24/03/2022

**Woolworths Warehouse and Distribution Centre Auburn-Mod-1 (SSD-10470-Mod-1)
Request for additional information**

I refer to the Modification Application for the Woolworths Warehouse and Distribution Centre Auburn (SSD-10470-Mod-1). We require additional information noted below:

Drawing Title:
Ground Floor Plan

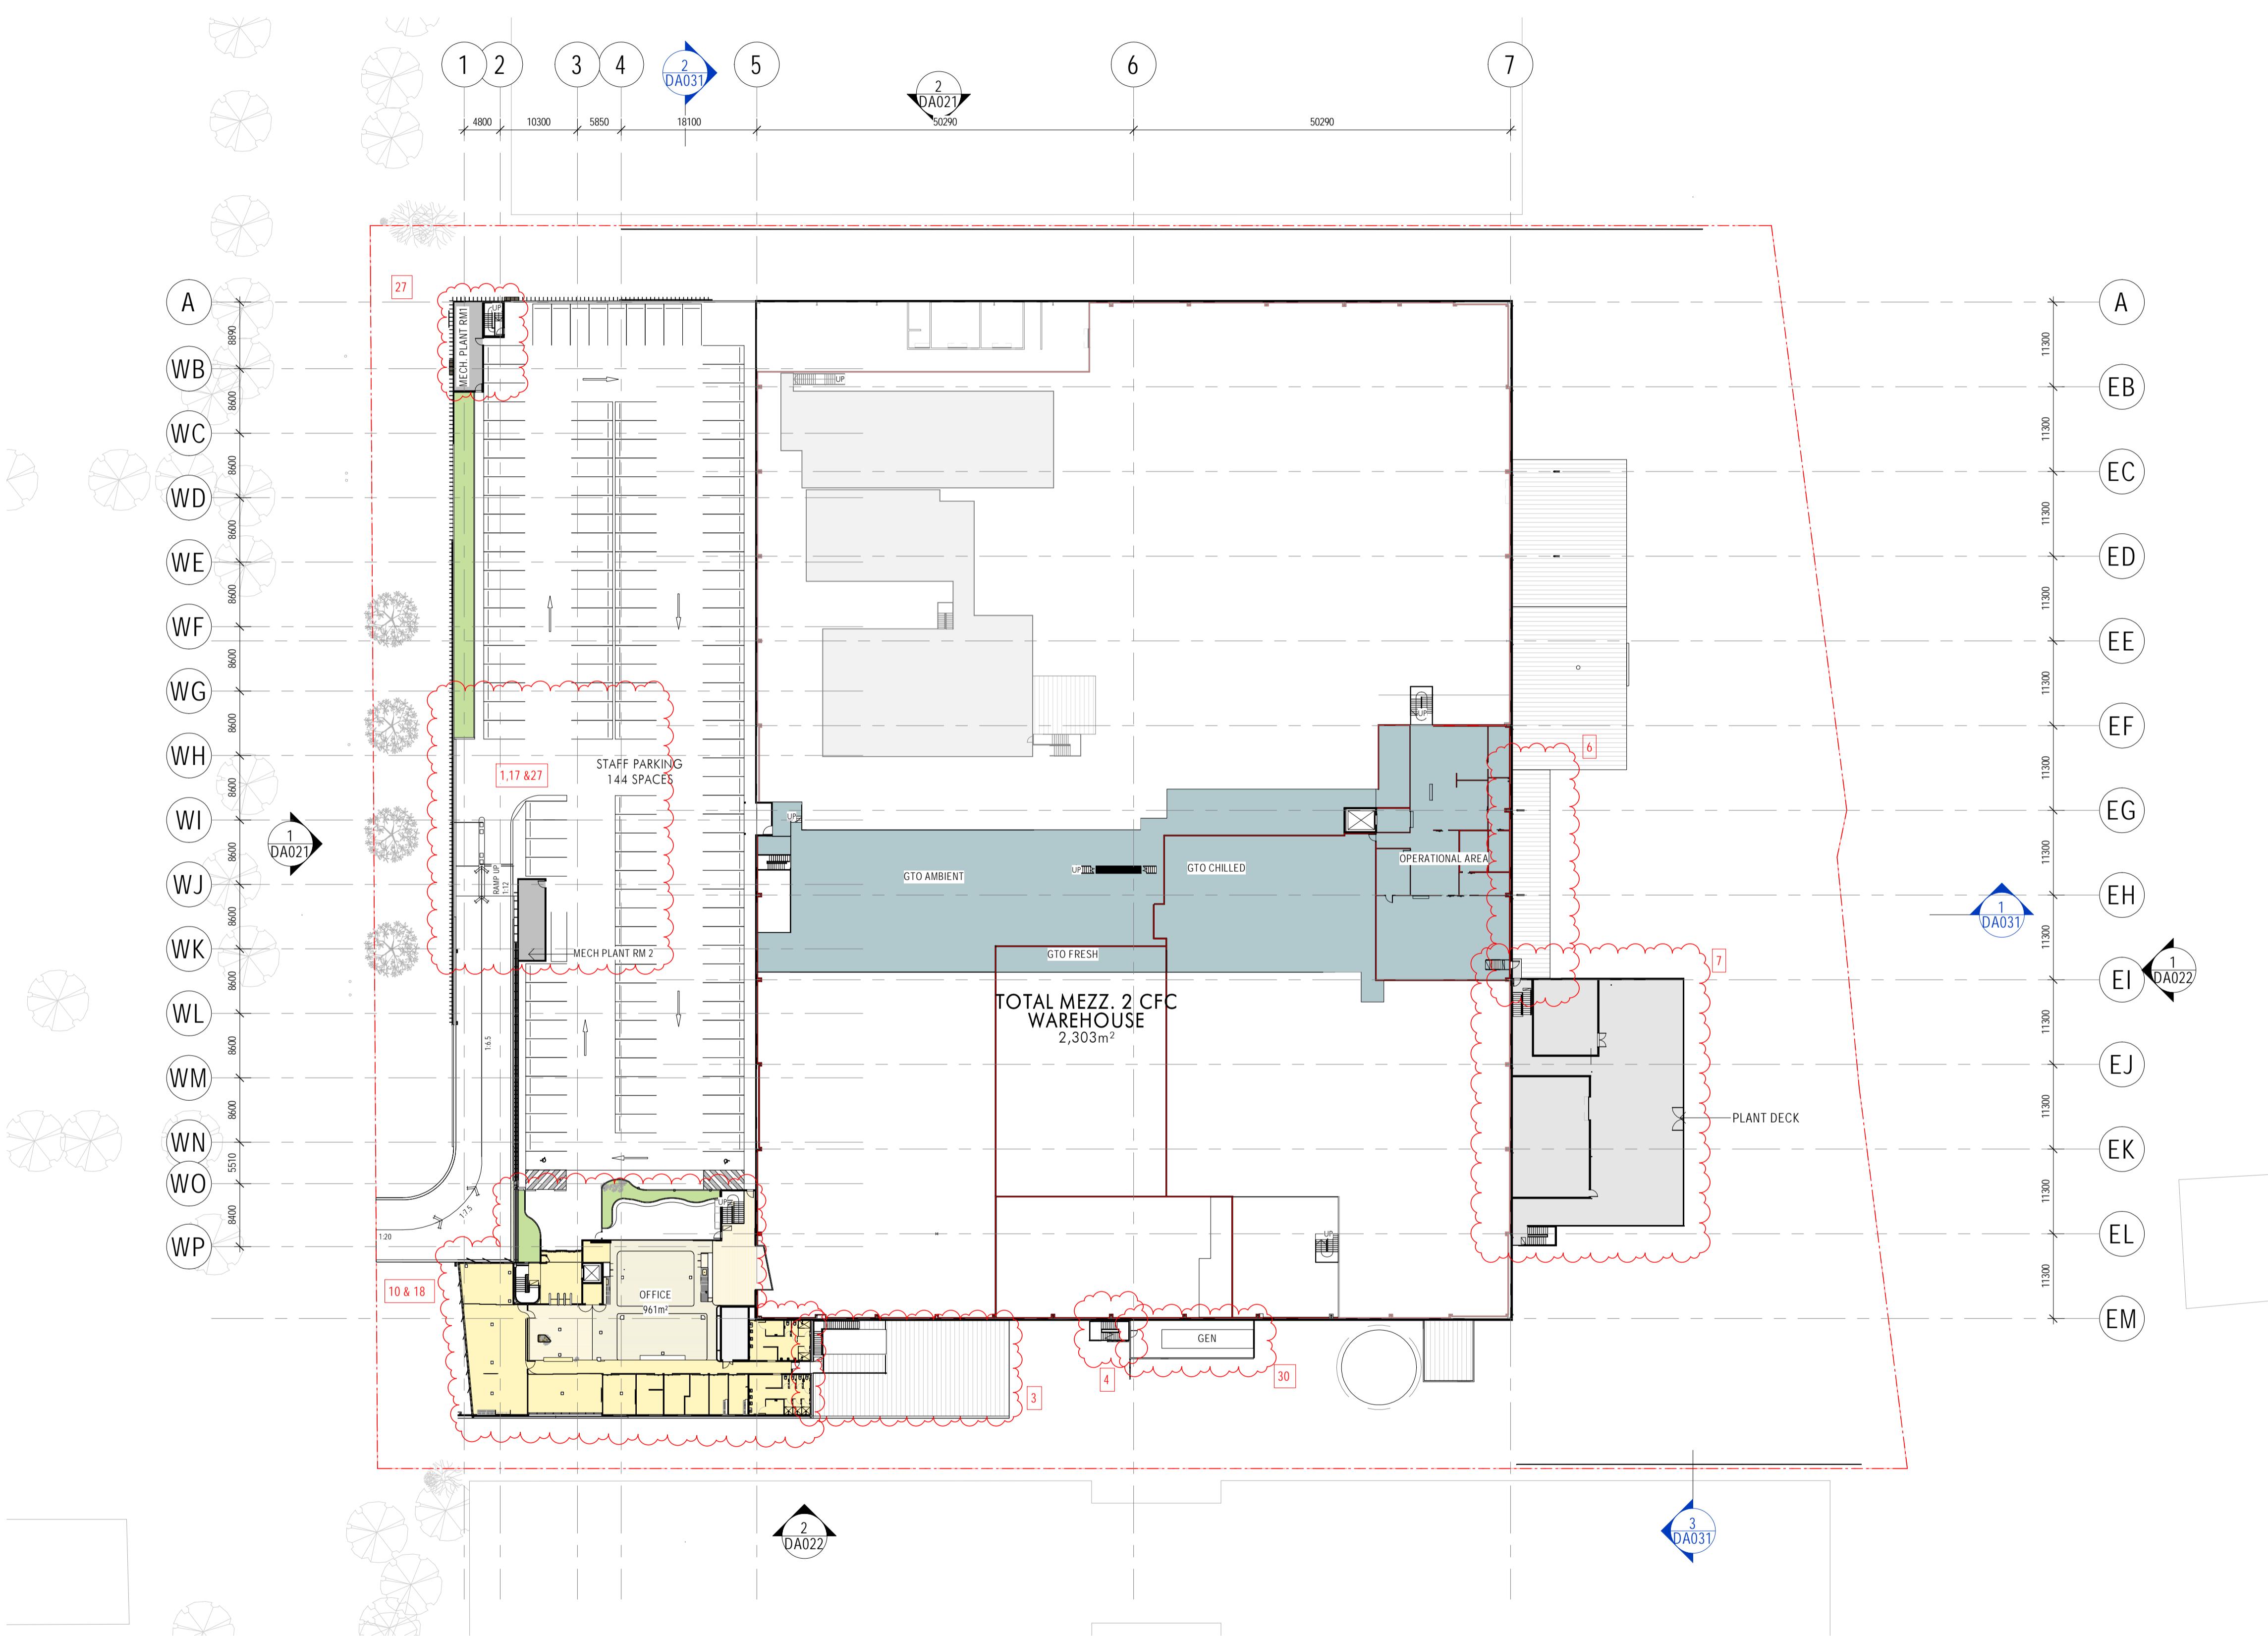
- Please provide details of your amendment request as outlined in your email correspondence of 22 March 2022, including updated plans, a justification for the changes and any environmental impacts associated with the amendments.
- Please clarify the purpose of the manual gates located on the inbound van entry and egress, outbound van entry and egress and pickup entry/egress/truck egress. Additionally, please clarify the hours of operation of the facility, and subsequently the hours that the manual gates will be open.
